**REQUEST**

Current Zoning: ML-1 (manufacturing and logistics-1)  
Proposed Zoning: ML-1(CD) (manufacturing and logistics-1, conditional)

Approximately 17.31 acres located along the east side of Twin Lakes Parkway and north side of Interstate 485, south of Sam Roper Drive.

The petition proposes an automotive repair facility, auto dealership, warehouse and distribution center and all other commercial and industrial uses as permitted by right and under prescribed conditions and accessory uses, as allowed in the ML-1 zoning district.

Rezoning Plan
 Charlotte NC 28212

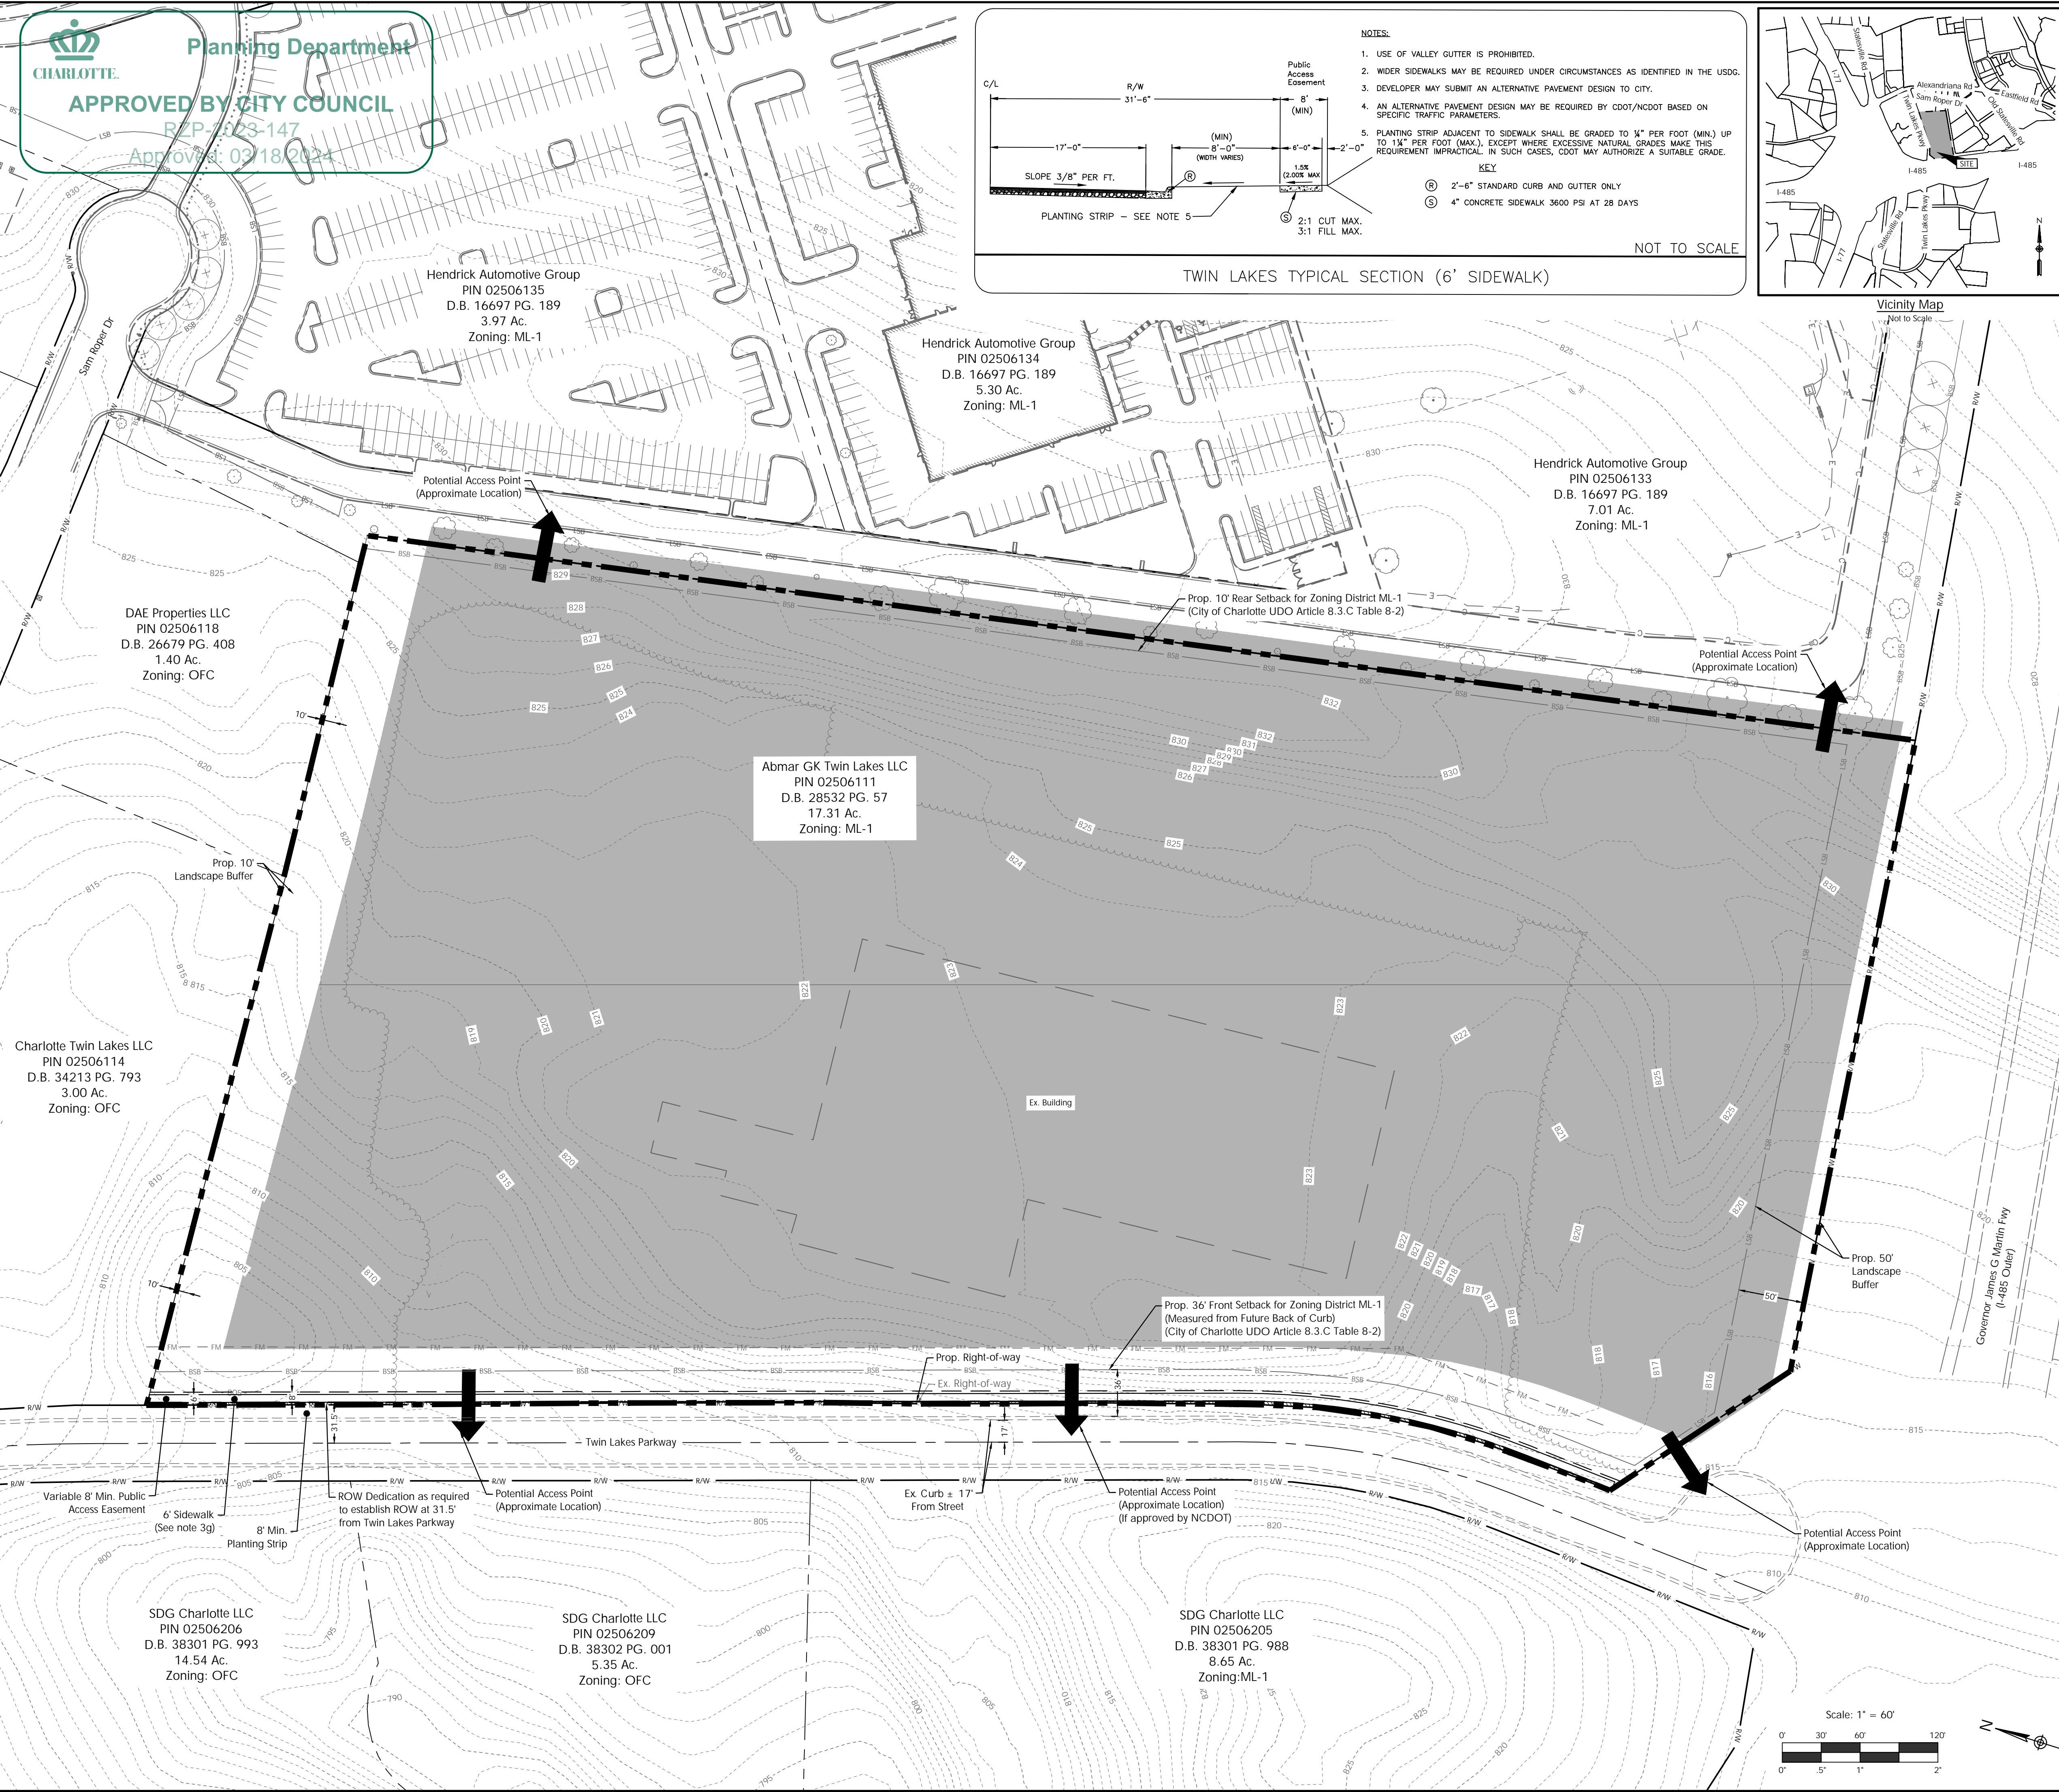
1. ~~Land use information has been added to the site plan but no density information. Please add maximum density information to the site plan to confirm data provided in trip generation memorandum.~~ Addressed

Proposed Zoning: 1,356 trips per day (based on 14,000 square feet of warehouse, 12,000 square feet of office, and 69,150 square feet of auto care center).
